Application Ref:	3/2021/0428	 <div>Ribble Valley Borough Council</div> <div>www.ribblevalley.gov.uk</div>	
Date Inspected:	02/07/2021		
Officer:	AB		
DELEGATED ITEM FILE REPORT:		Decision	APPROVED

Development Description:	Proposed extensions to side and rear, and first floor extension. Remodelling of layout including integral garage with bedroom suite over.
Site Address/Location:	8 Hammond Drive Read BB12 7RE

South Elevation
1:100 Scale

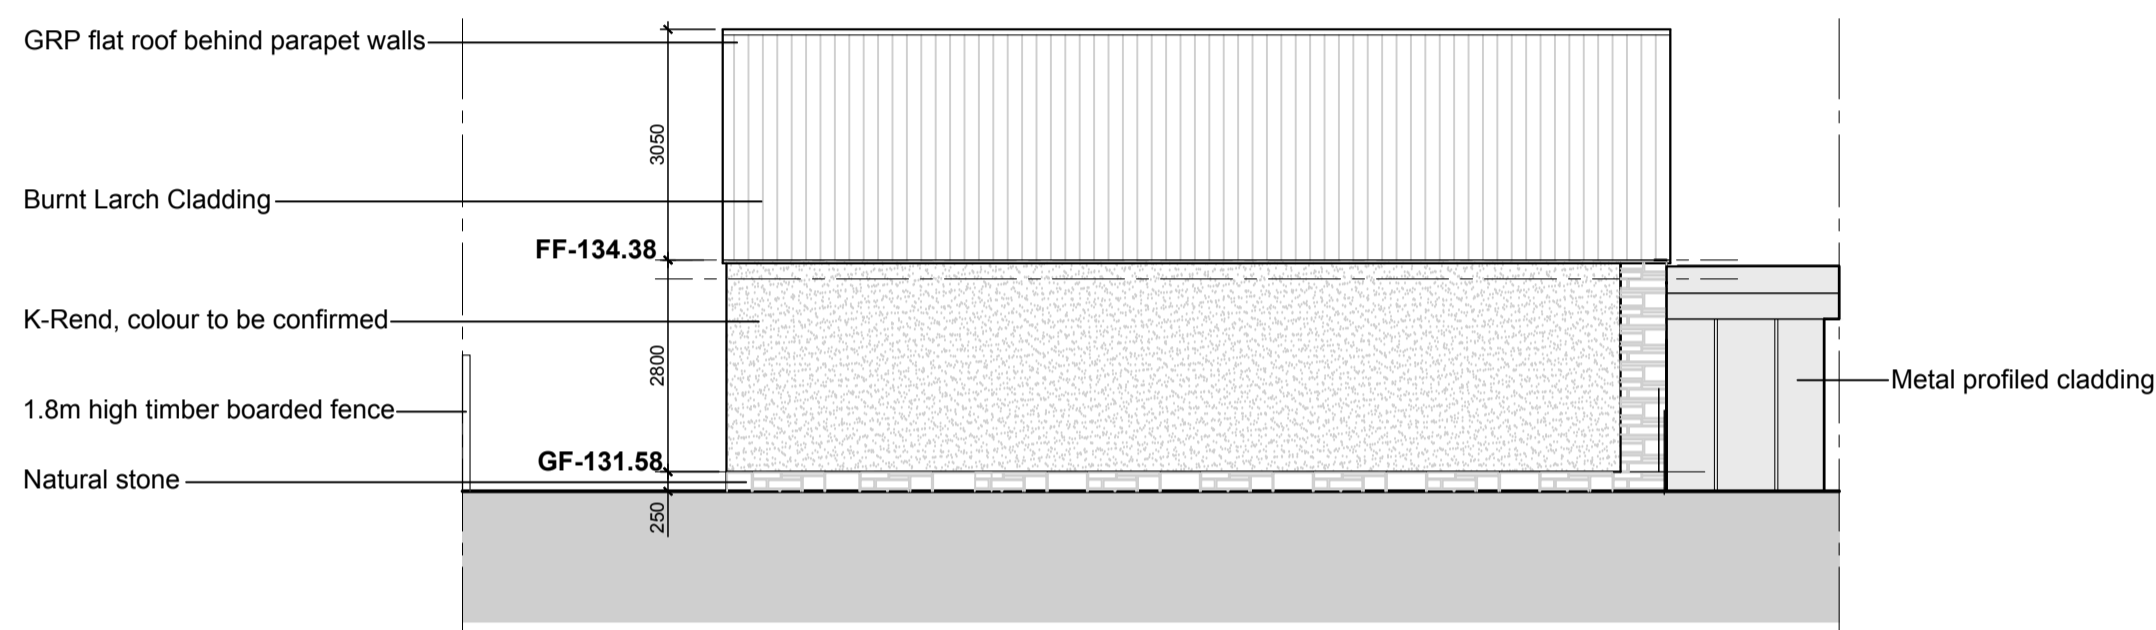
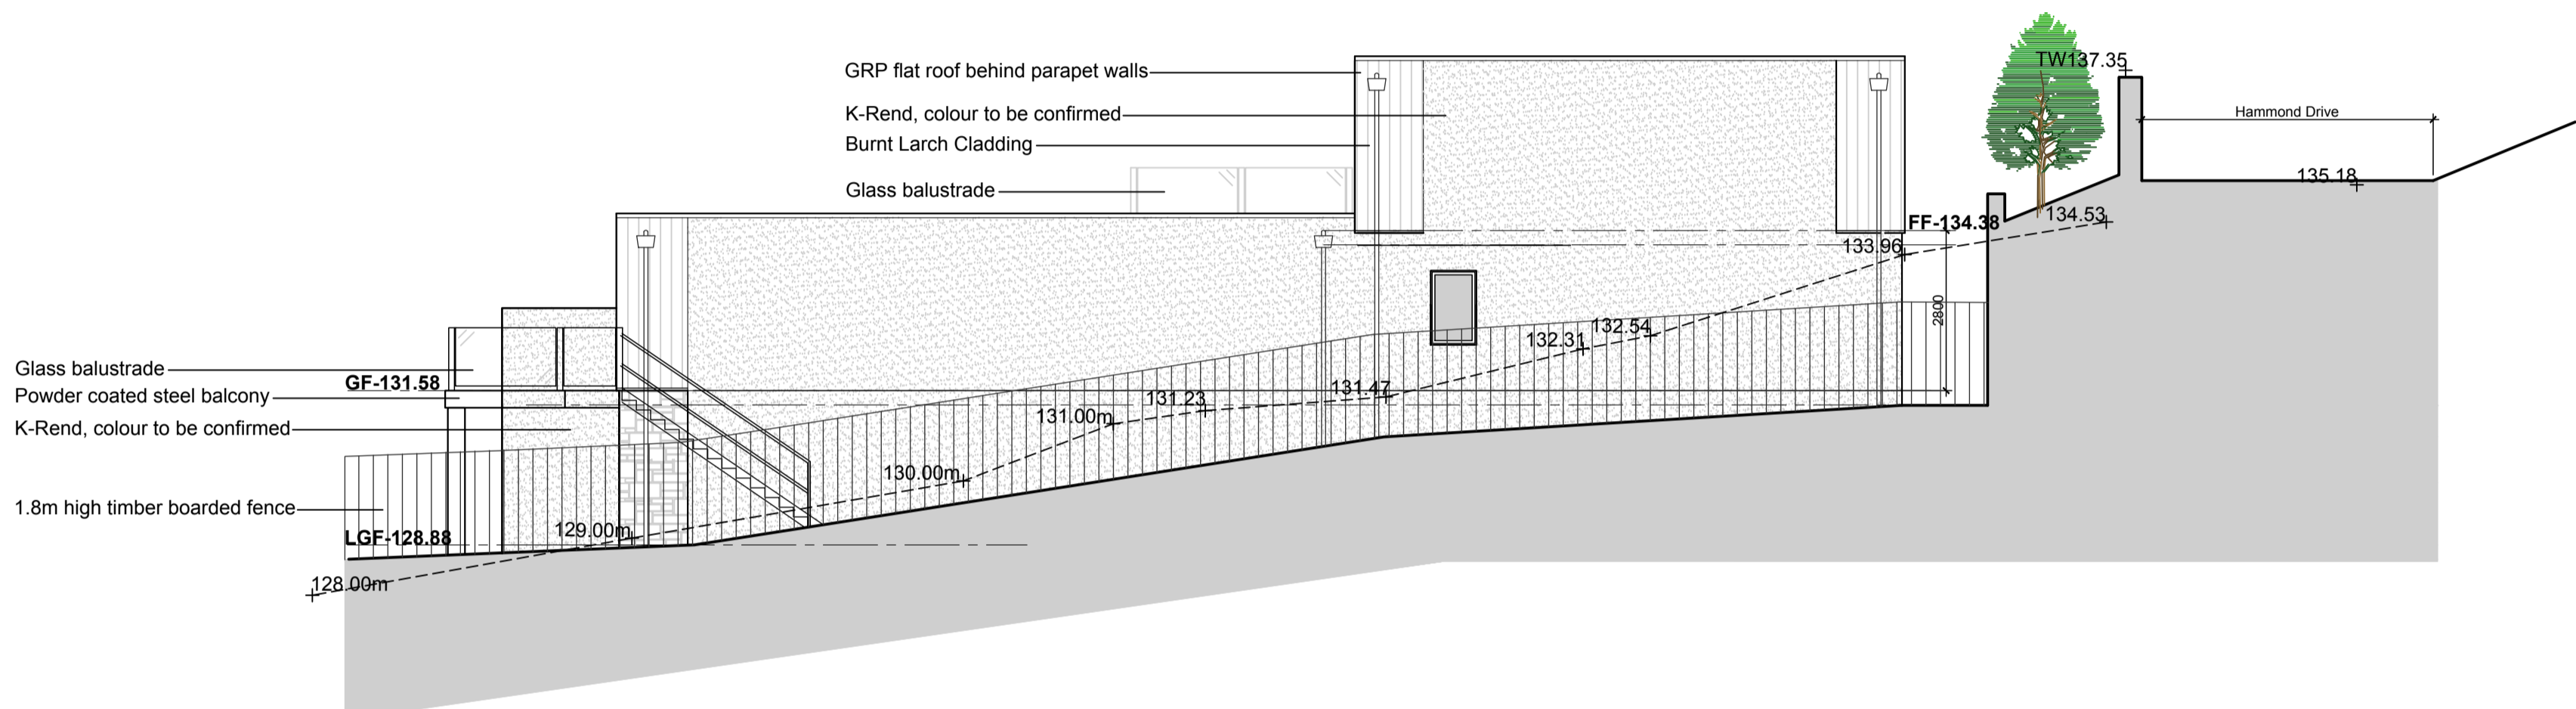
To the west is 10 Hammond Drive, a newly built property. This dwelling is built further south on lower ground. There would be some overlooking of the side garden associated with 10 Hammond Drive from the south-facing ground floor balcony of the application dwelling. However, there is already an existing timber balcony on the rear of the application dwelling at present, and it is not considered that the proposed development would result in any additional loss of privacy when compared with the existing arrangement.

Of concern is the proposal to increase the rear garden level of the application plot to create a level garden. The natural land level slopes to the south and the garden of the adjacent property, 10 Hammond Drive, generally follows the natural contours of the land. Levelling the rear garden as proposed would result in a considerable level change along the shared boundary between 8 and 10 Hammond Drive. As submitted the application also denoted the requirement for a 1.8m high gabion wall along the southern boundary which faces onto open agricultural land known as Hammond Ground, recognised as a landscape of high quality.

Following discussions with the applicant it is agreed that the rear garden levels would remain as existing.

Client Mr John Houston			
Job Title Proposed Alterations to 8 Hammond Drive Read			
Drawing Title Proposed Floor Plans			
Scale 1:100 @ A1	Date April 2021	Drawn Craig Harrison

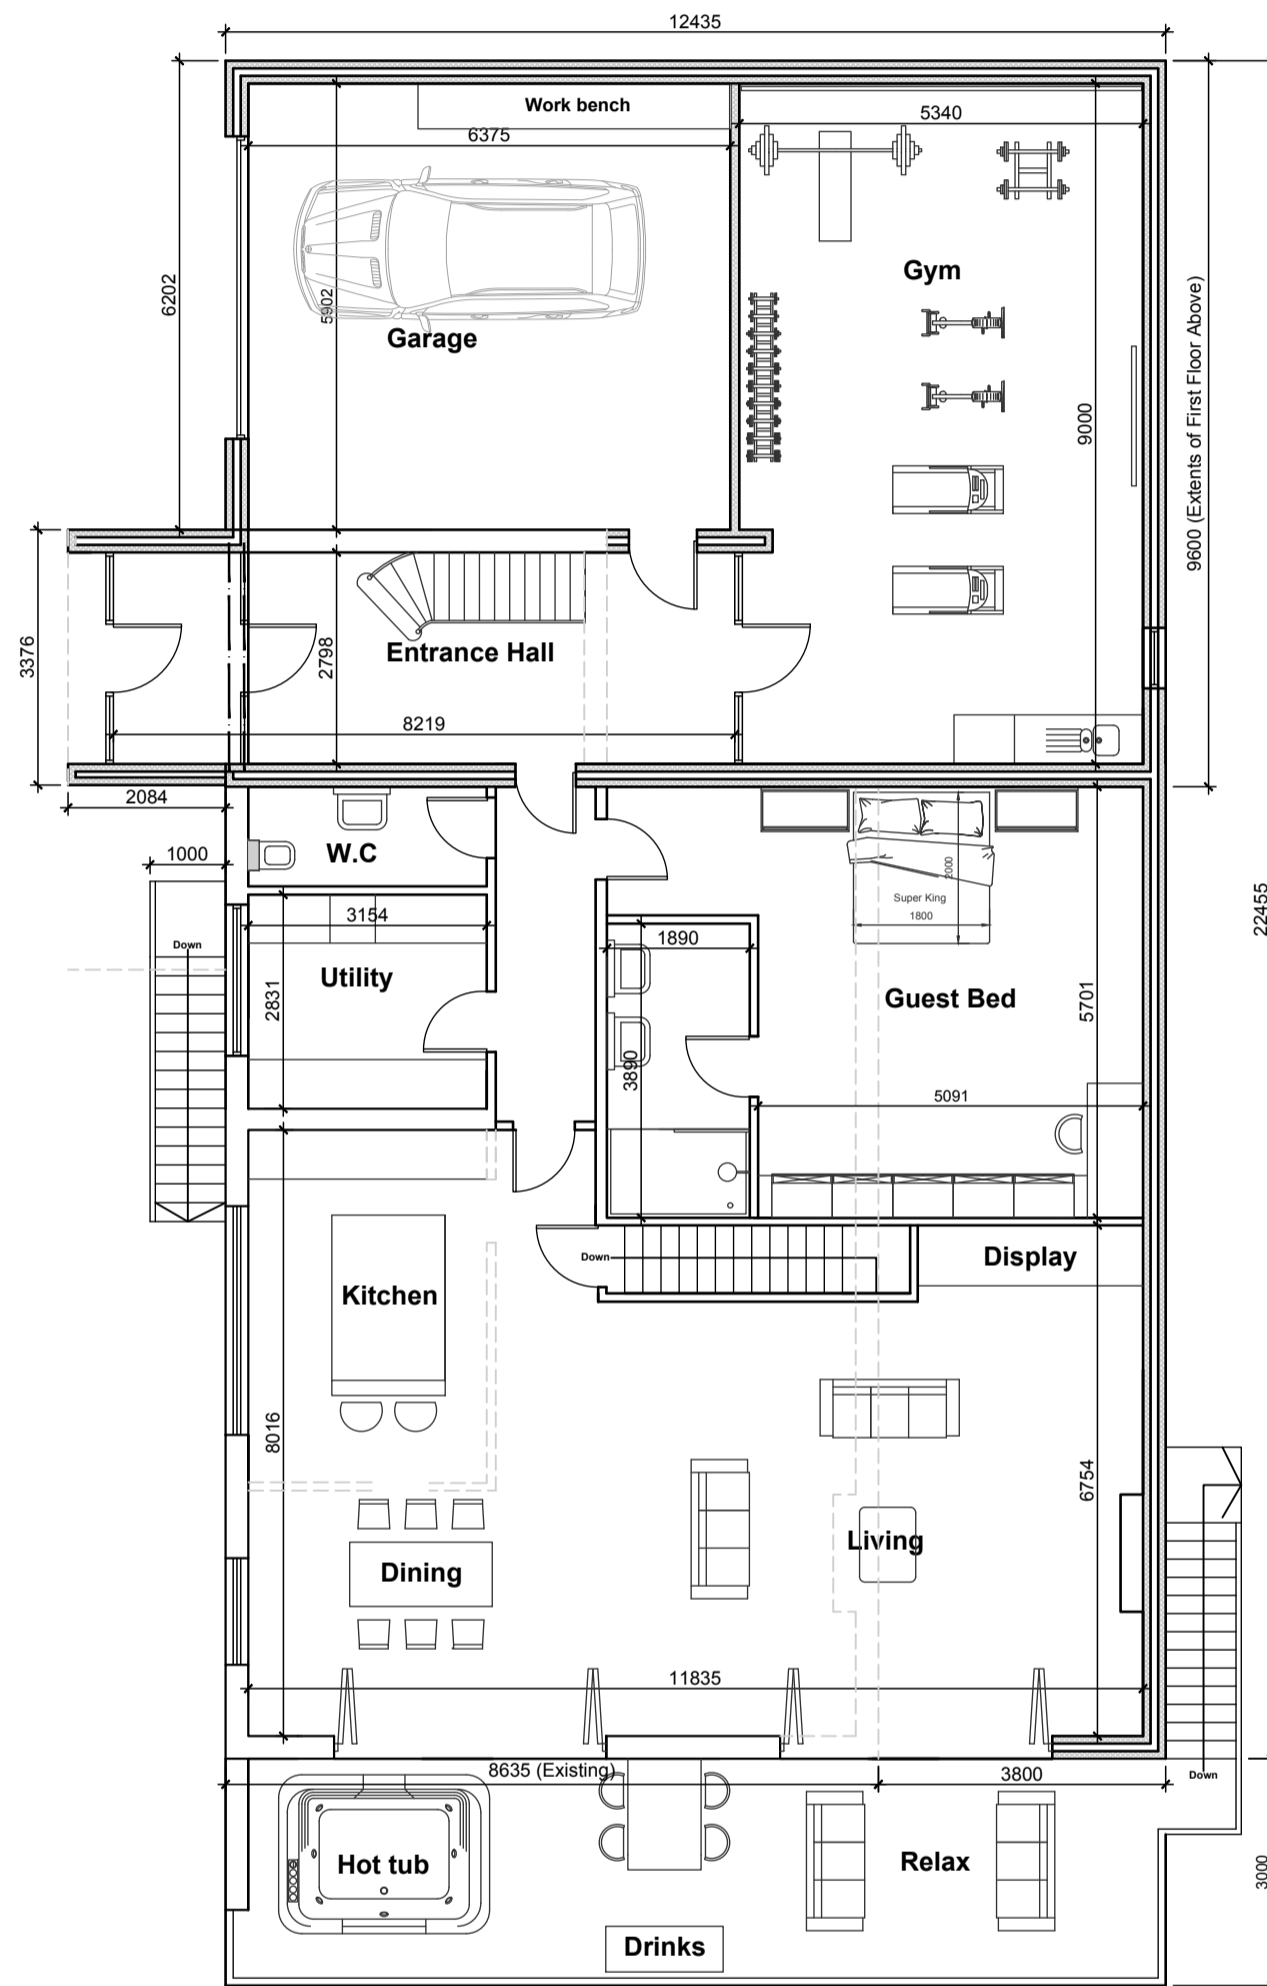
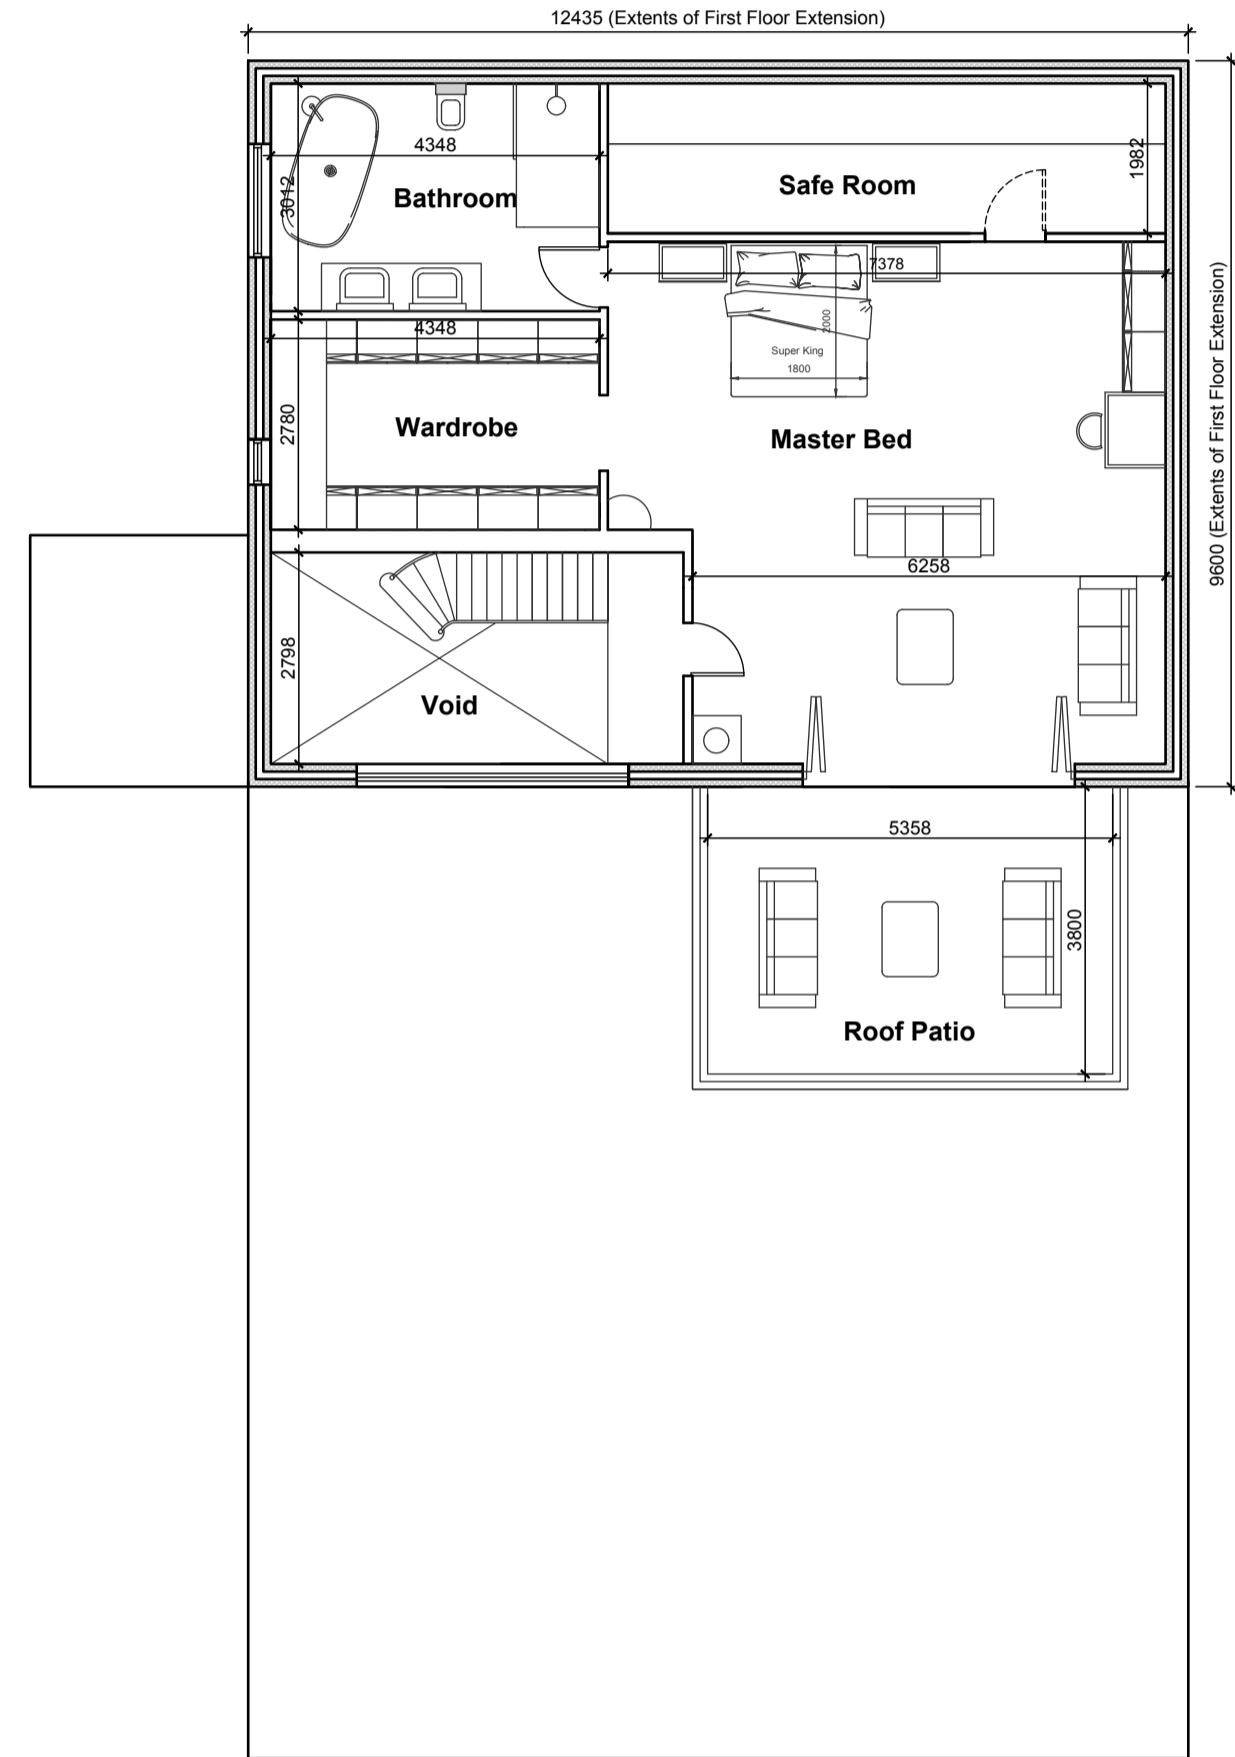
The County Surveyor has raised no objections to the proposal. However, concerns have been raised in relation to the site layout which would include the construction of a wall and gates in an existing open hardstanding area to the front of the application dwelling. The proposed parking space contained within the walled area would be difficult to manoeuvre into and the Highways Officer has advised that the gate be relocated, or the area left open as existing.

Subsequently the site layout has been slightly altered and the width of the garage door has been widened to ensure that two cars can be accommodated. There would be a conditional requirement that the garage remained available for the parking of vehicles at all times and this would ensure that there is sufficient space within the plot to manoeuvre.
